OXFORDSHIRE COUNTY COUNCIL'S RESPONSE TO CONSULTATION ON THE FOLLOWING DEVELOPMENT PROPOSAL

Application no: 15/01012/OUT-2

Proposal: OUTLINE - Development of up to 48,308sqm of employment floorspace (Class B1c, B2, B8 and ancillary B1a uses), the siting of buildings to the south of the site, servicing and circulation areas, vehicular and pedestrian access from Skimmingdish Lane and landscaping

Location: Land North East Of Skimmingdish Lane Launton Oxfordshire

Figure 3 – Footpath 272/17 Proposed Location

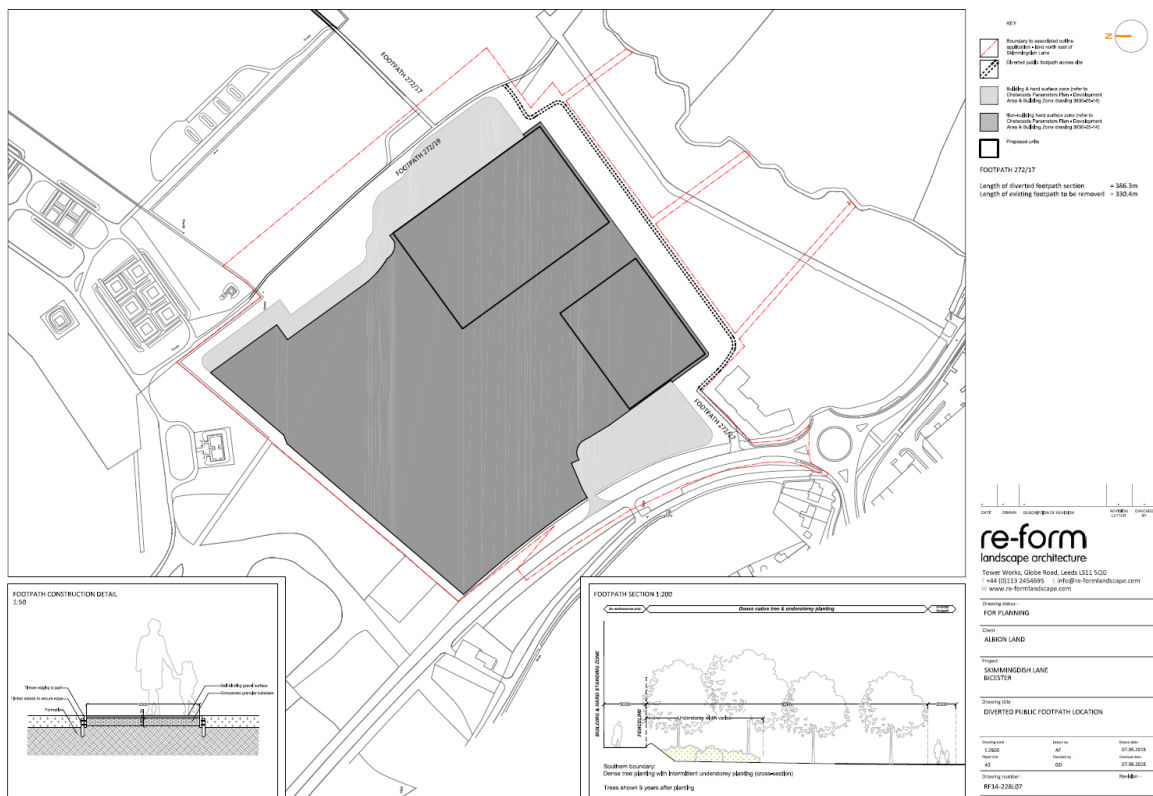
This planning proposal requires a public footpath [Launton Footpath 17 (272/17)] to be diverted under the Town and Country Planning Act 1990 section 257. The county council has made comments on the Pre-Order Consultation for the footpath diversion, expressing concerns over the proposed route and in particular that it created four right angled bends. The Design and Access Statement says that *'the route of the diverted right of way replicates the linear form of paths in the locality and the pattern of right angle turns or junctions along the network'*. Whilst some footpaths do have right angle bends this is usually at a junction of paths or where a path meets a physical boundary.

The amendments to the building and hard surface zones to the south-east of the site means that there is an increased area of planting and landscaping. It would therefore be possible to provide a diverted path through this landscaping area which could have gentle, curved changes in direction rather than the proposed right angle bends. We would like to see the proposals for the footpath diversion changed to create a path with smooth transitions in direction that will feel more direct and less harsh than that currently proposed.

JOB TITLE Skimmingdish Lane, Bicester		CLIENT Albion Land	
DRAWING TITLE Site Accessibility Plan			
SCALE NTS	DRAWN BY BP	DATE May2015	DRAWING No 15230-04
REVISION A

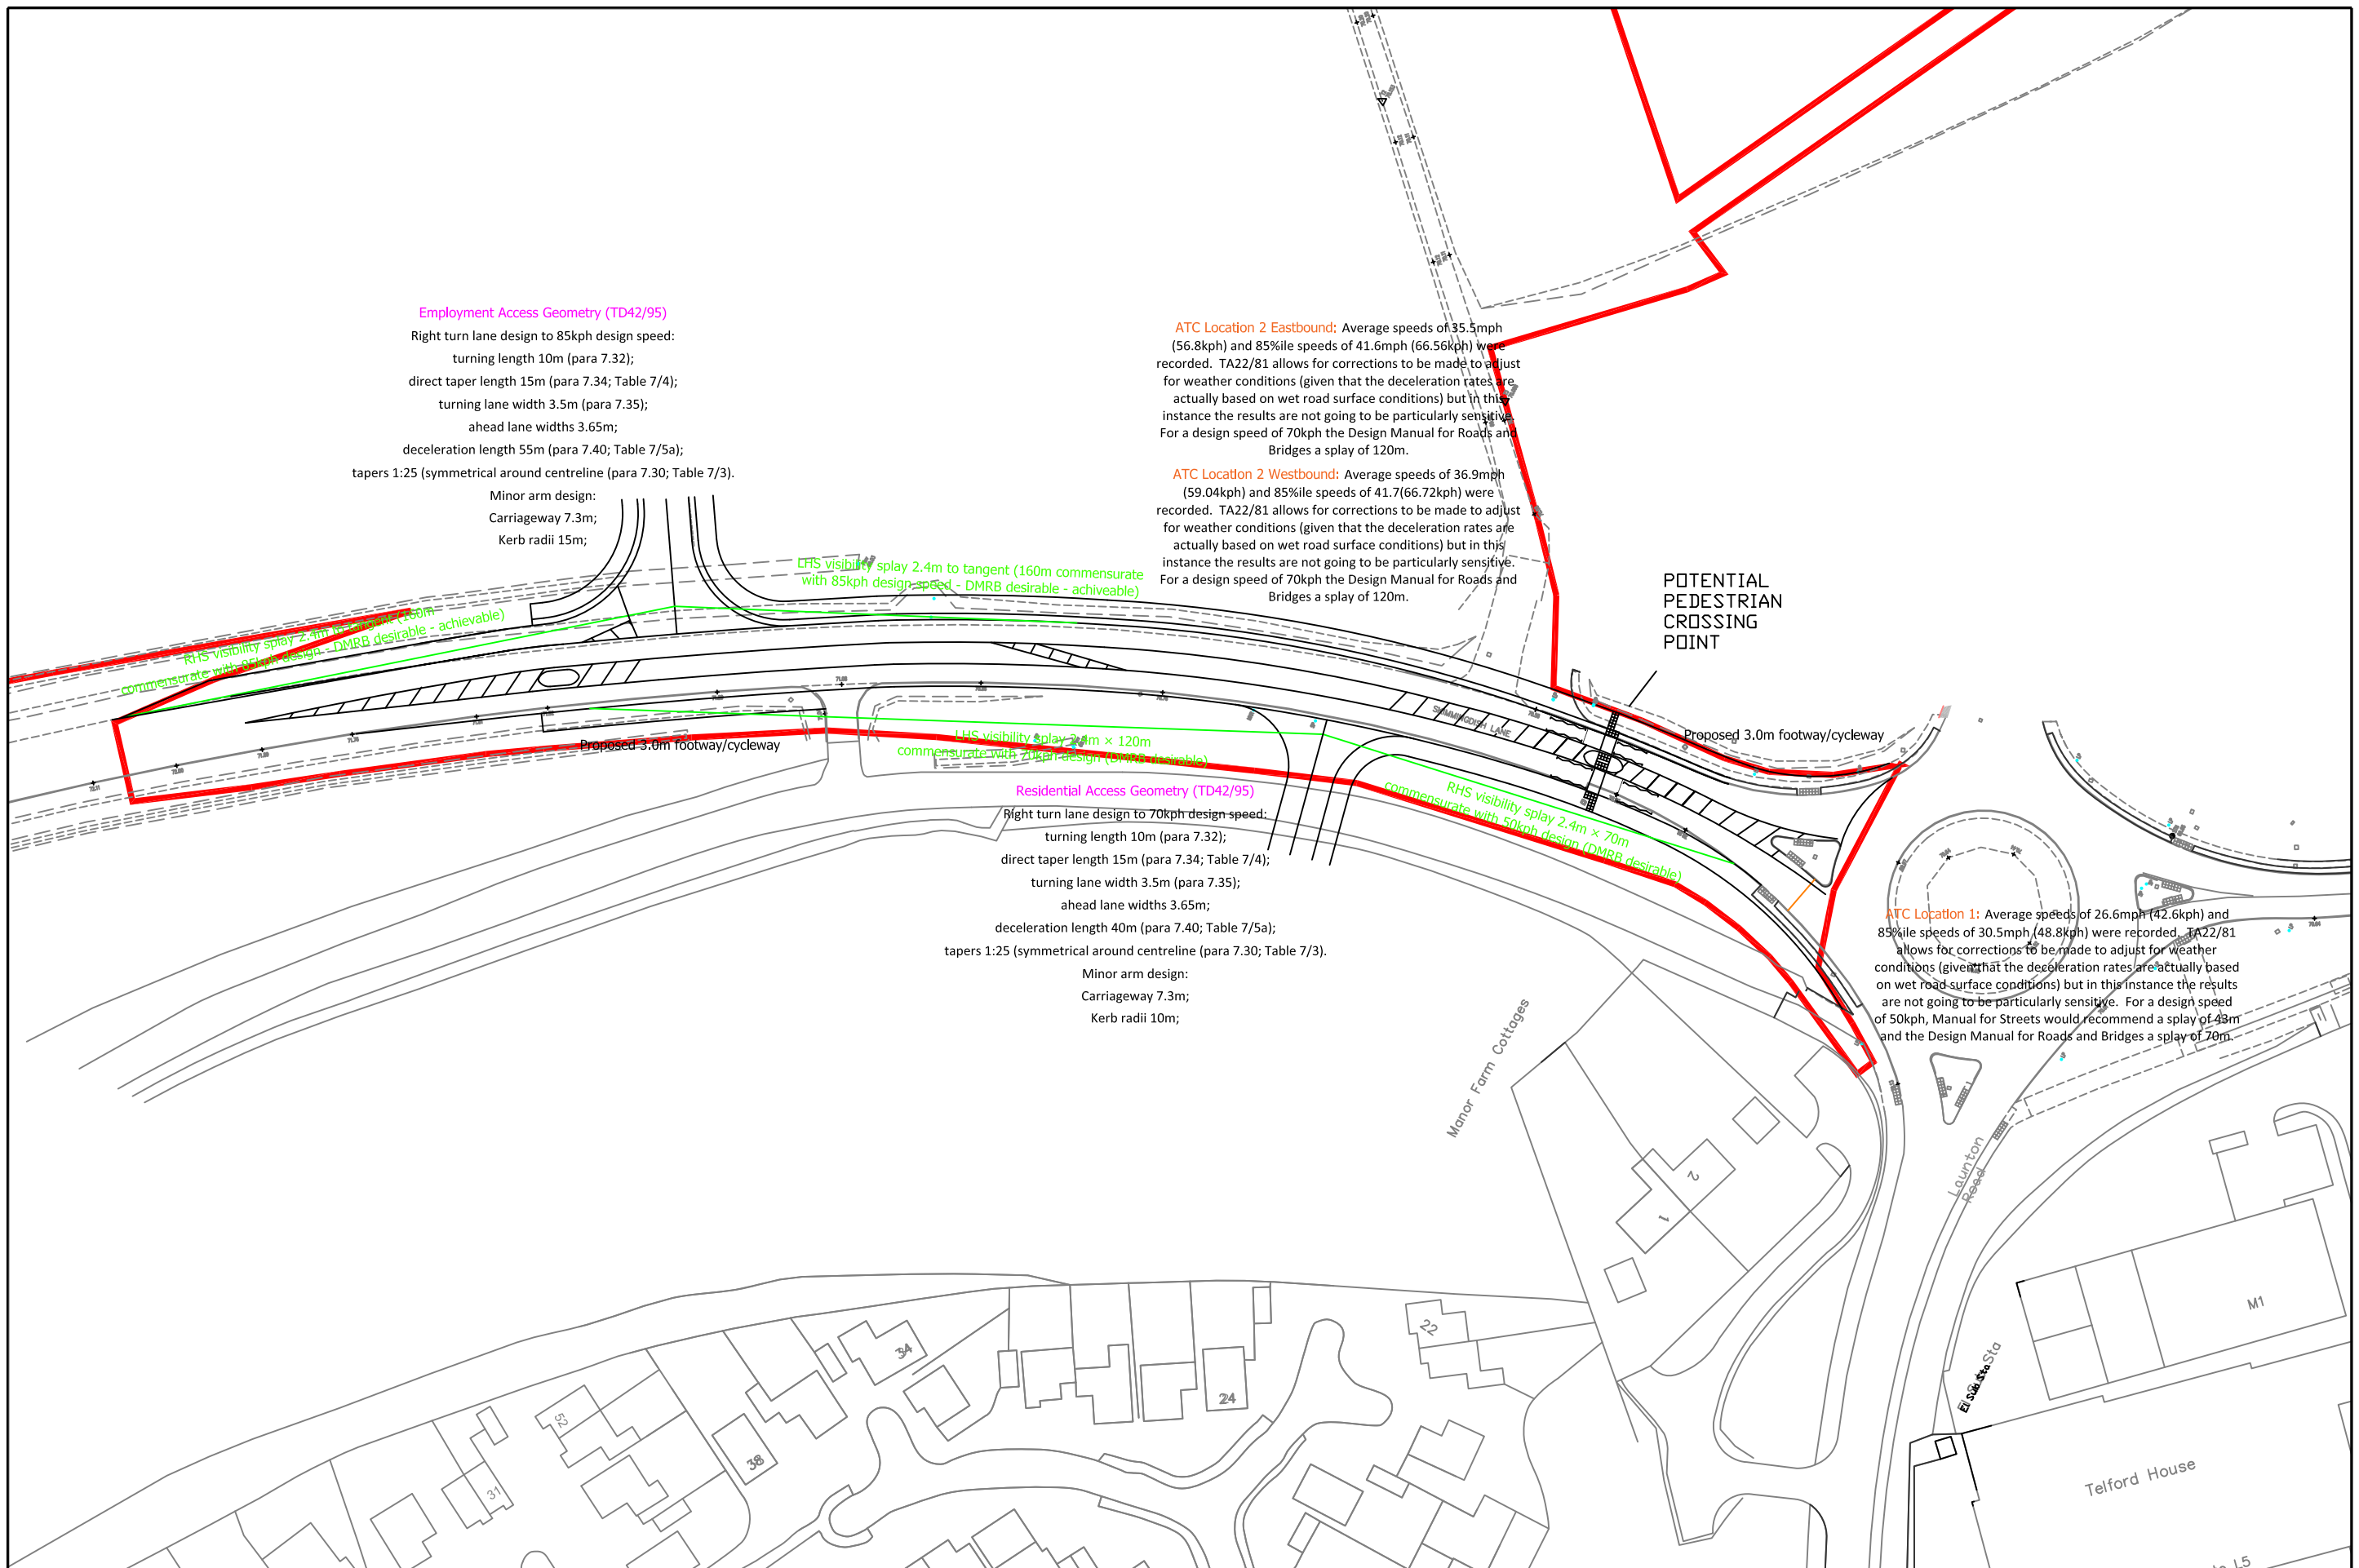
- This request is not disputed but no commitment is made. The Transport Assessment says that the developer is still in discussion with Stagecoach.
- The TA says that if the service to the development is provided, bus stops including laybys and shelters will be provided closer to the development as shown in indicative drawing 15230-04. This would be acceptable in principle.

JOB TITLE Skimmingdish Lane, Bicester		CLIENT Albion Land	
DRAWING TITLE Site Access Proposals (with Taylor Wimpey Access)			
SCALE 1/1000@A3	DRAWN BY BP	DATE May 2015	DRAWING No 15230-08
REVISION A

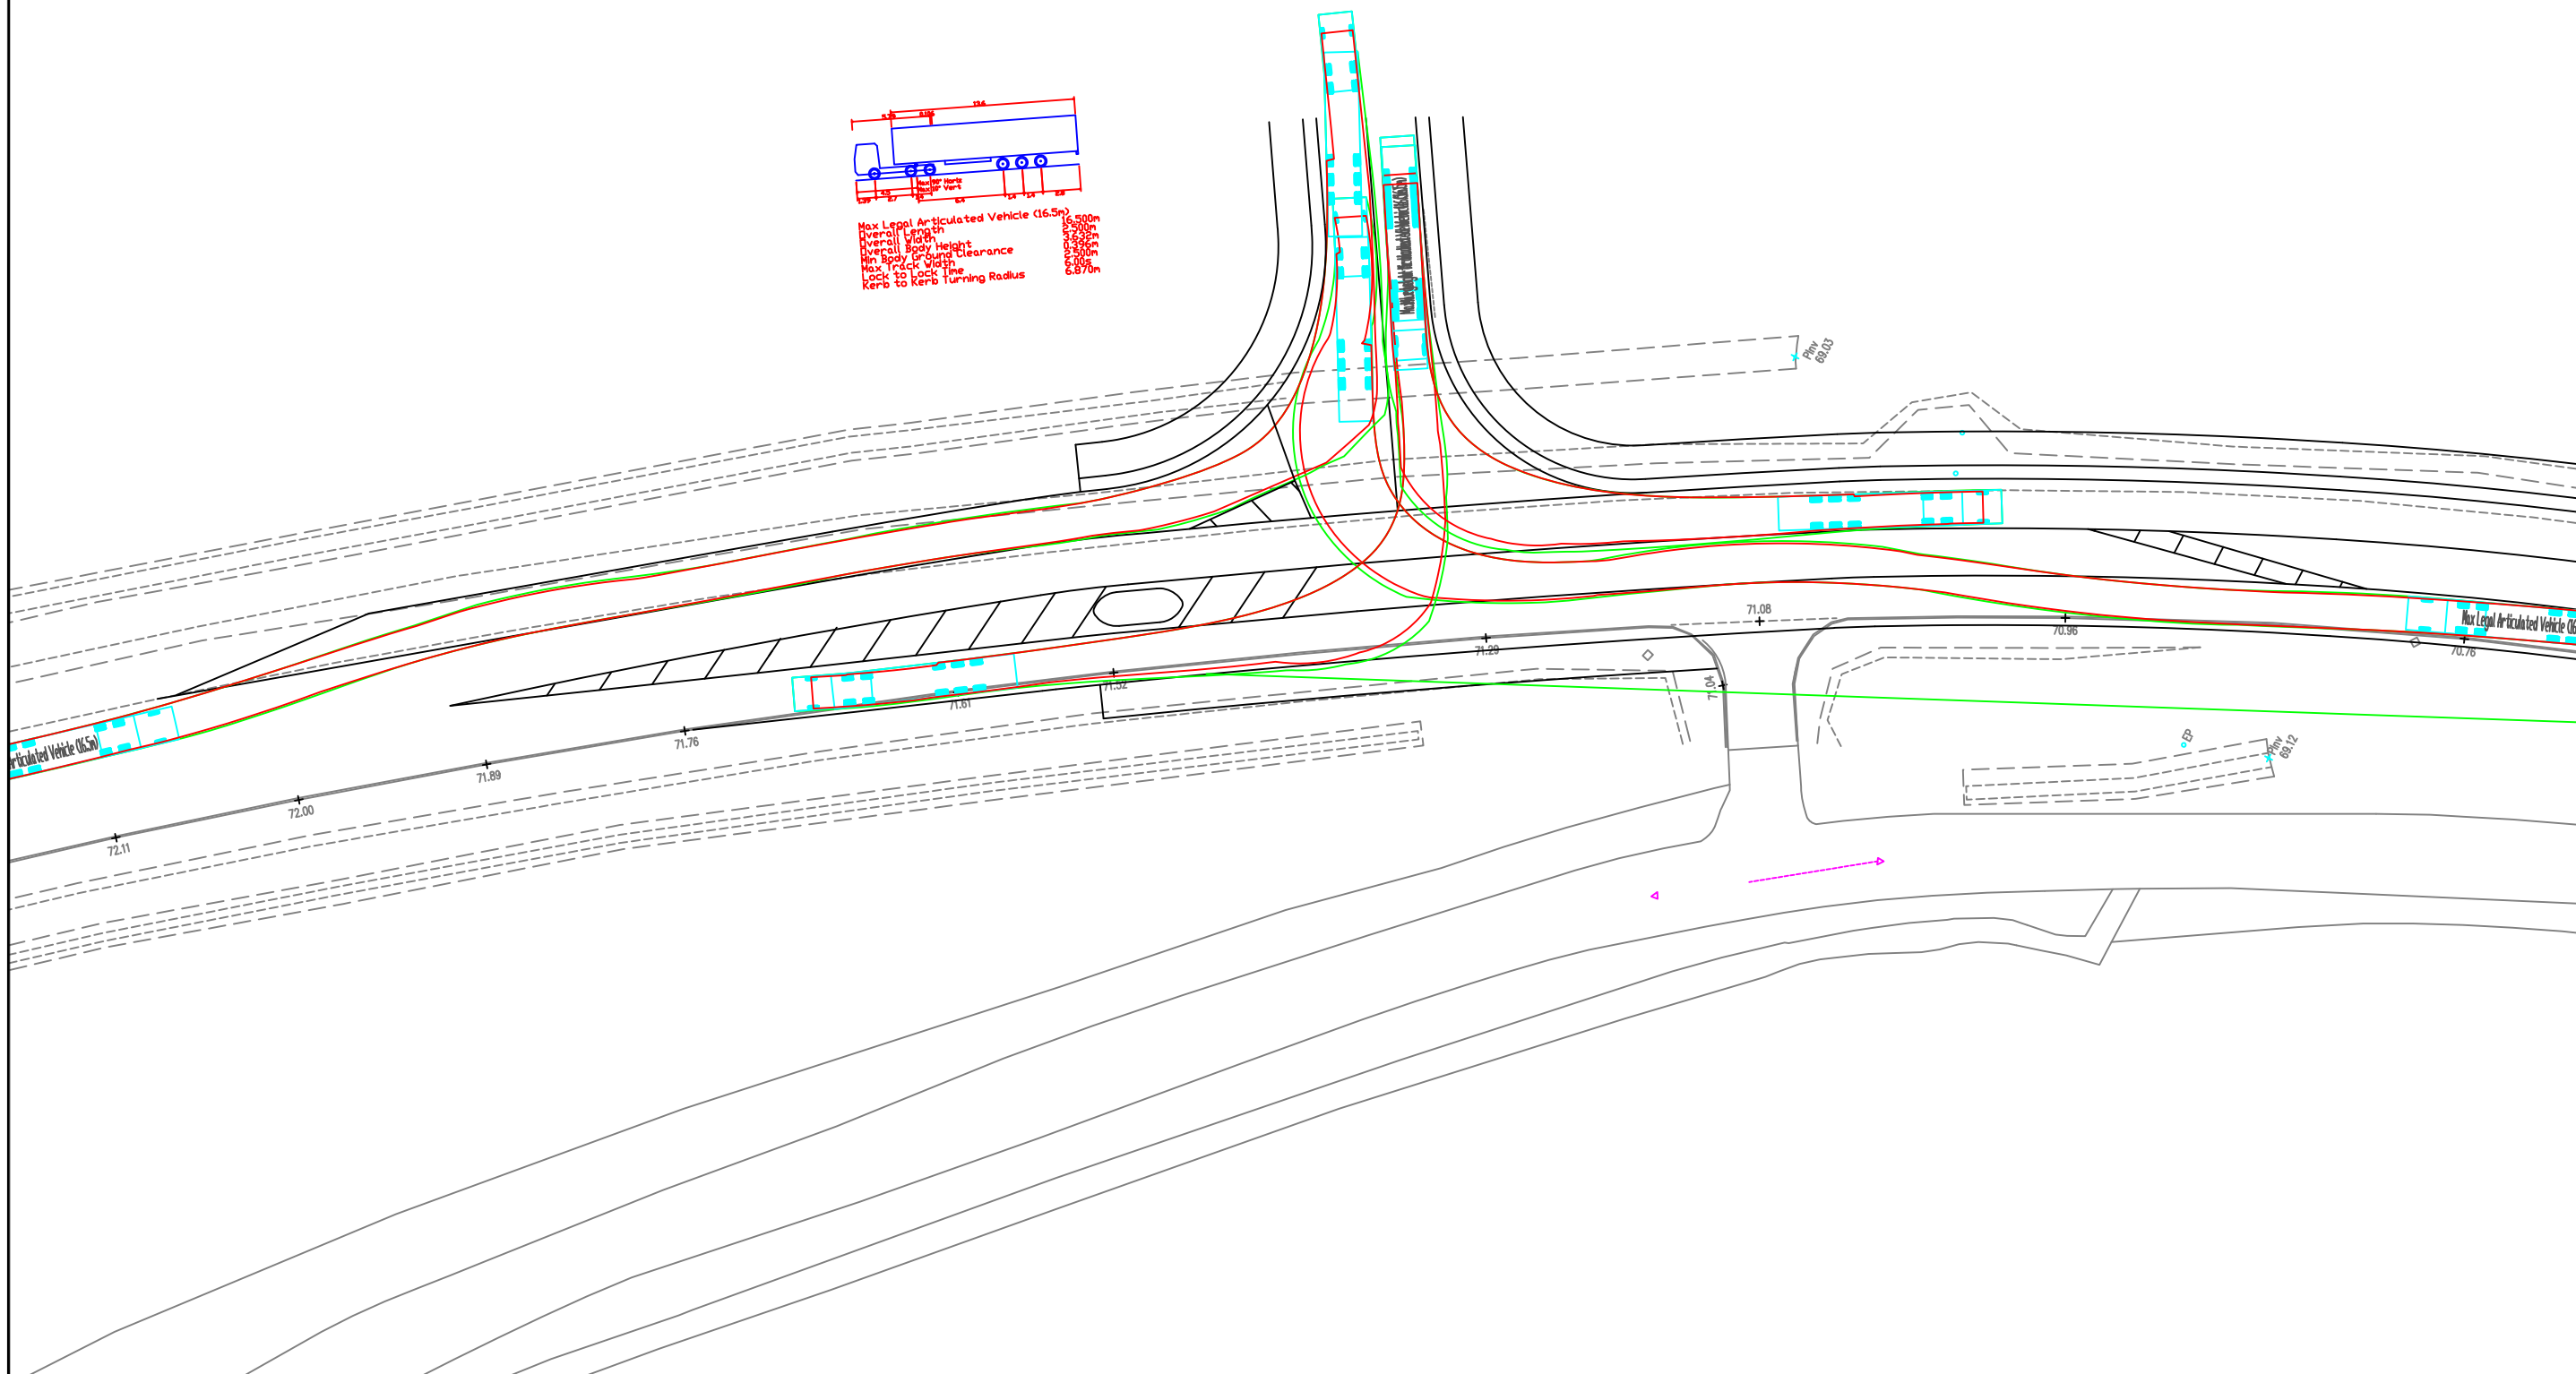
- Priority junction with ghosted right turn, footway/cycleways, signalised crossing, as shown on indicative drawings 15230/07 and /08 in the transport assessment. Note that this drawing will need to be amended to demonstrate commitment that streetlighting will be provided between the site access and existing lighting near the Launton Road roundabout.
